Addendum No. 2

RE: Contract # C203923

Brunswick County

1 Section of US-74/US-76, 2 Sections Of NC-179 and 41

BRUNSWICK COUNTY

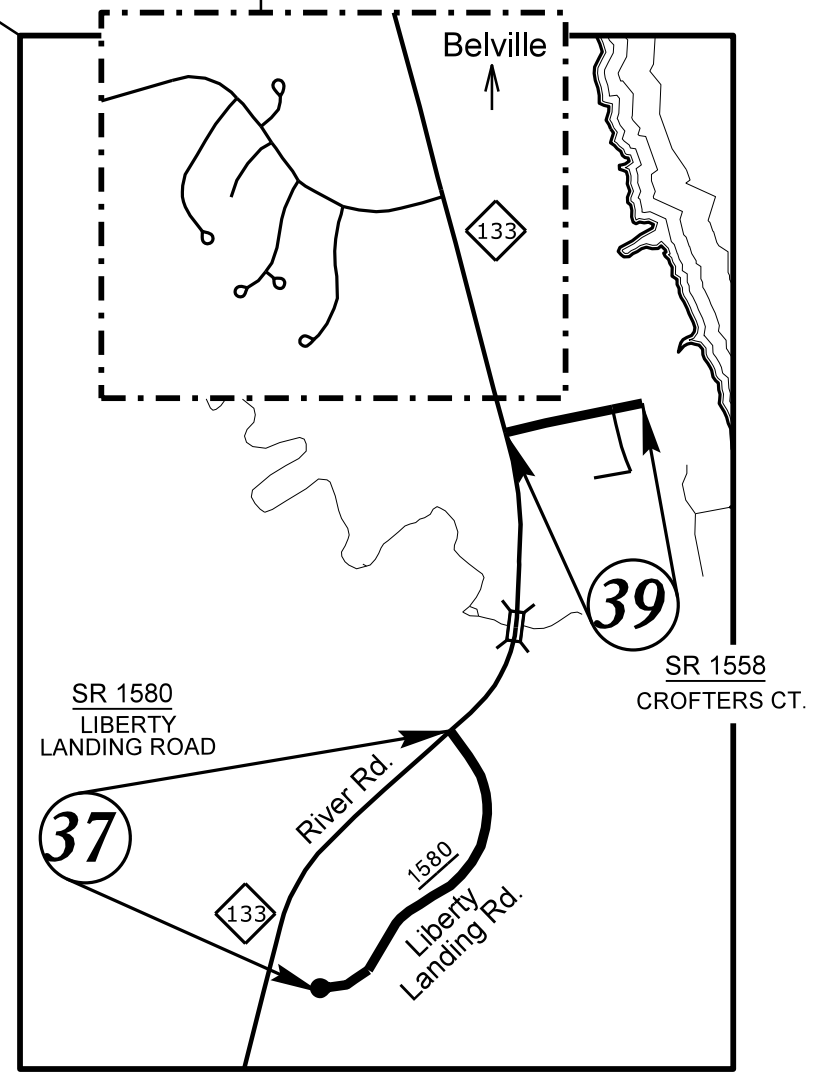
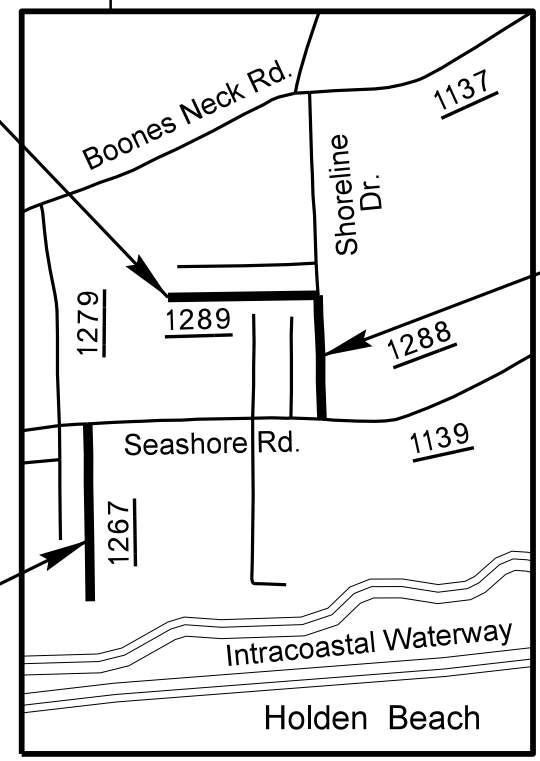
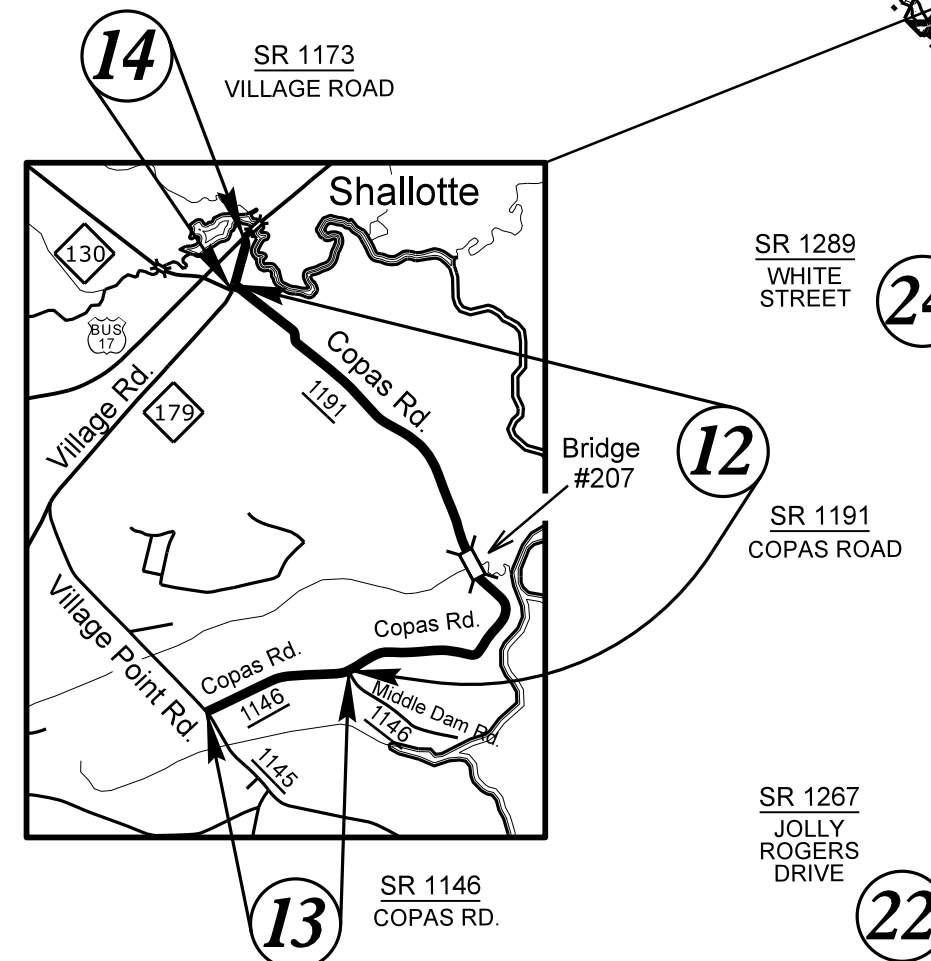
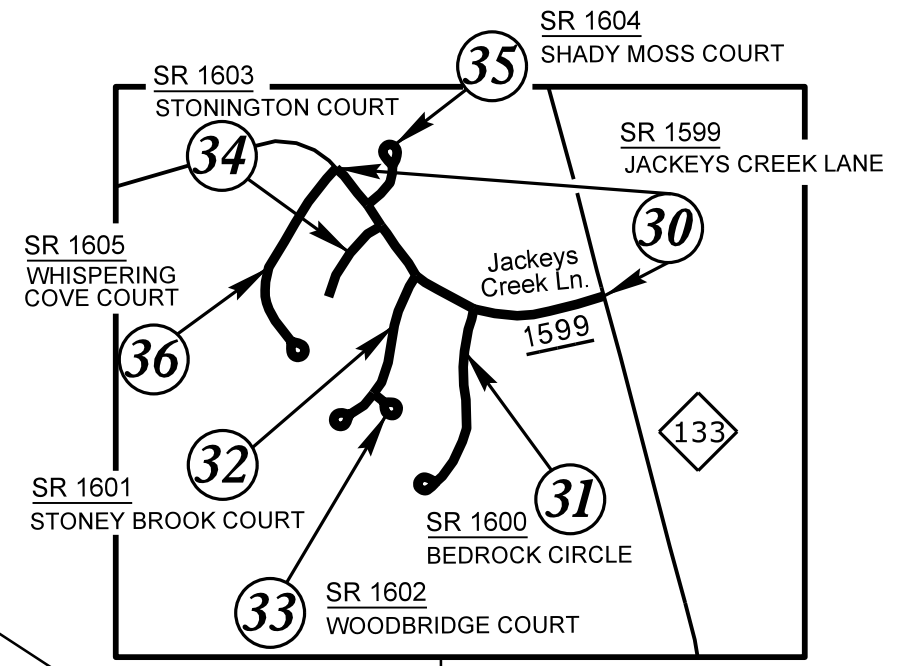
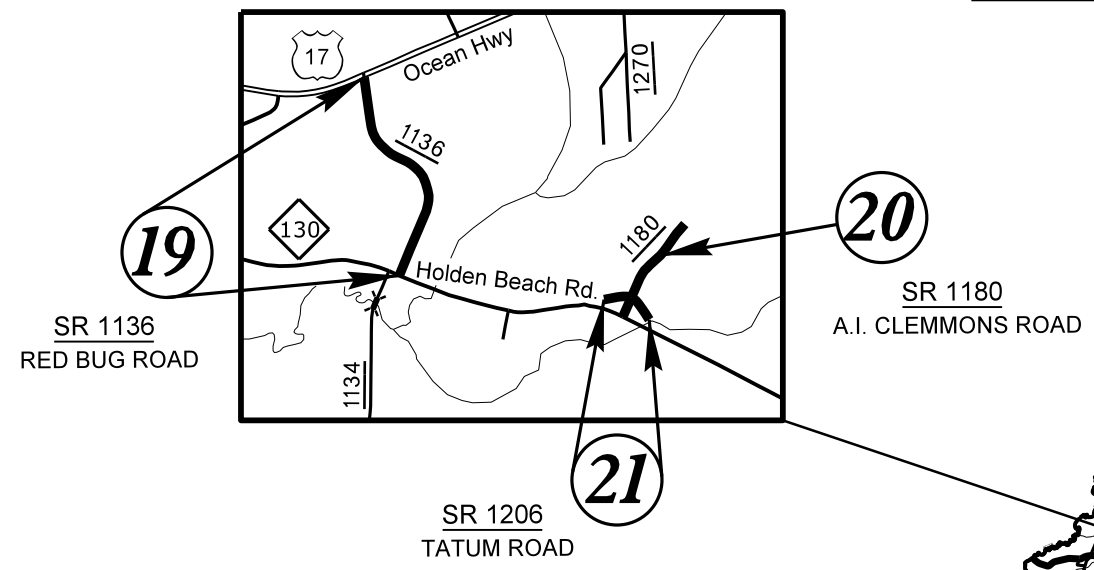
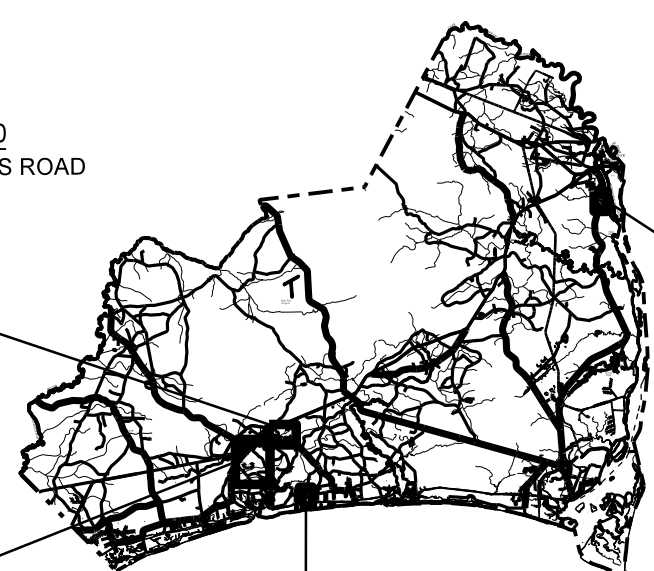
Sheet No.	Revisions
17 & 18	Revised the column "Final Surface Testing Required" for Map 3 to indicate that no final surface testing is required
